Your Ref :
Our Ref : M/69/12/NMA

Application for a non-material amendment following a grant of planning permission M/6/12/ to change thatched roof covering & side facing 'eyebrow' window to plain tiles & roof light with obscured glass
125 Middleton Road, Middleton-on-Sea, ,

PROPOSED ELEVATIONS

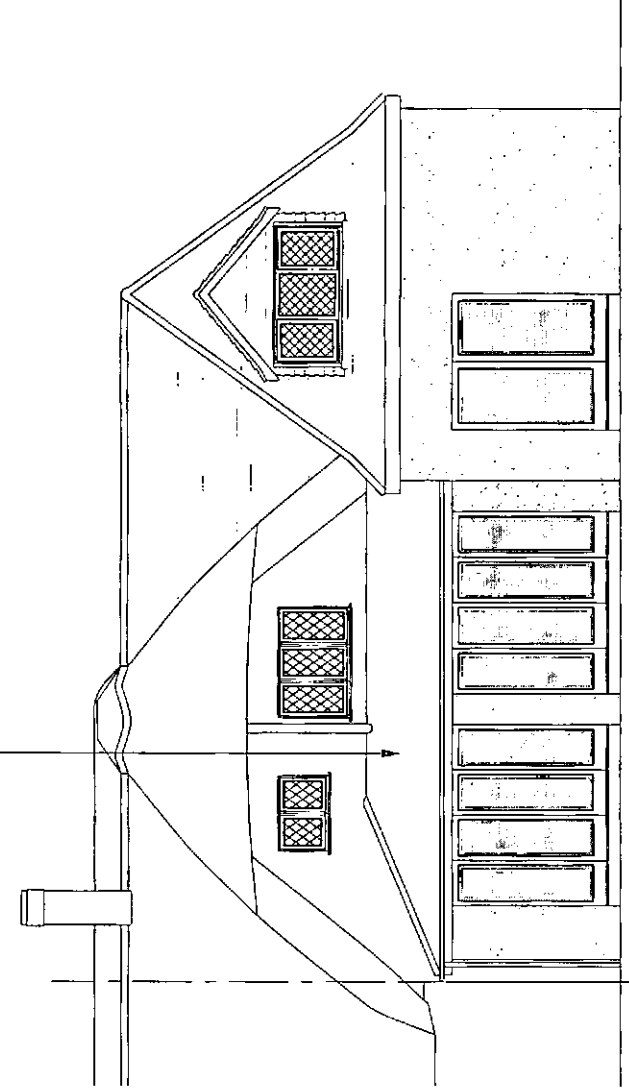
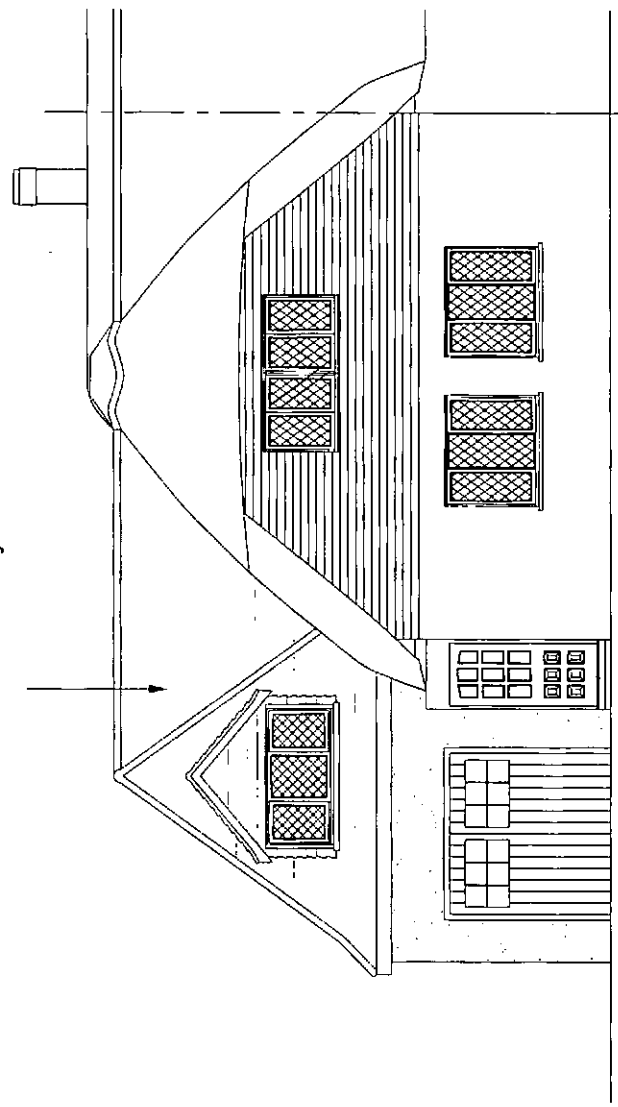
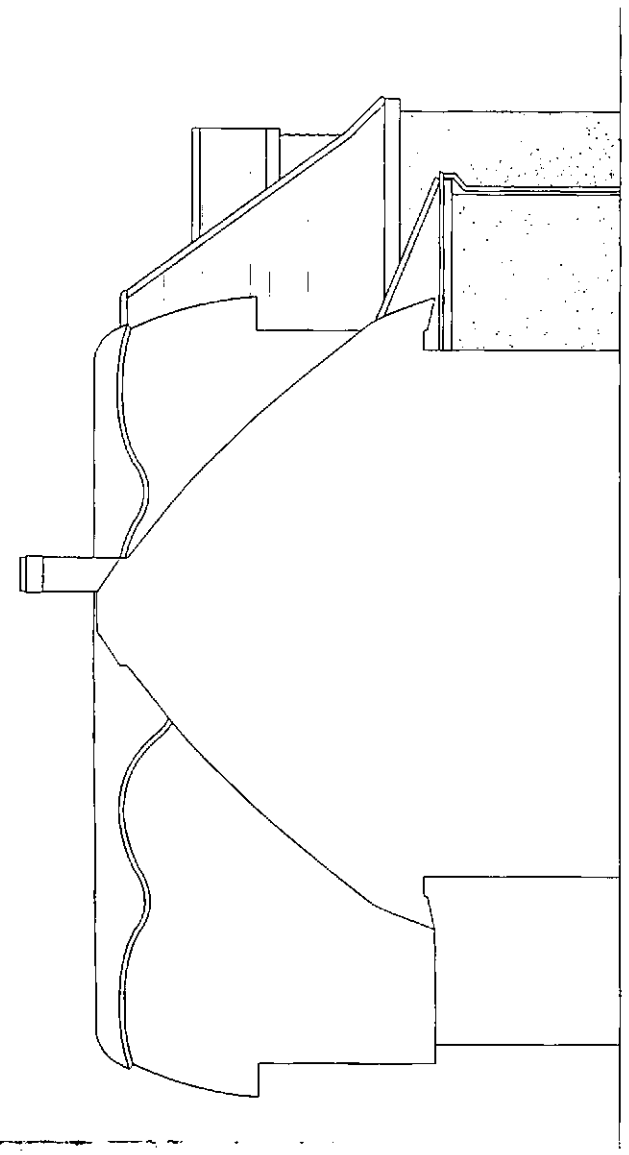
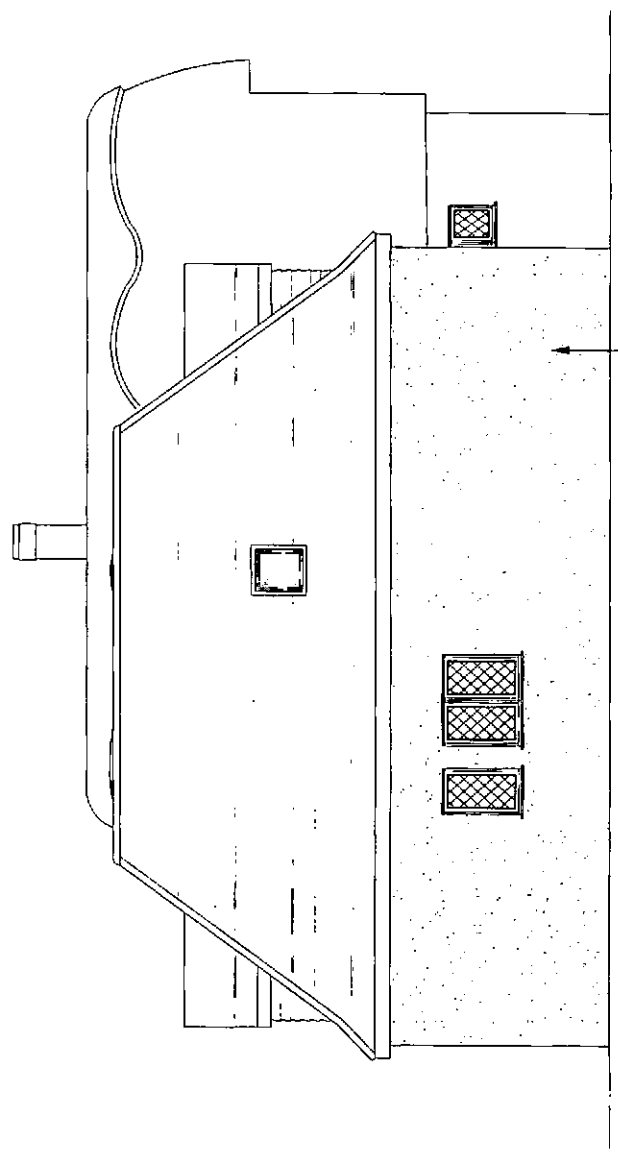
From the submitted drawing 'proposed elevations' , it is proposed to have a plain tiled roof (Goxhill Clay Bridle Mix) in place of thatch on the approved two storey side extension (M/6/12).

On the basis of the submitted drawing, I am minded to accept the change as a Non Material Amendment.

Please be advised that drawing 'proposed elevations', dated 13 September 2012, is now the approved drawing for application M/6/12/.
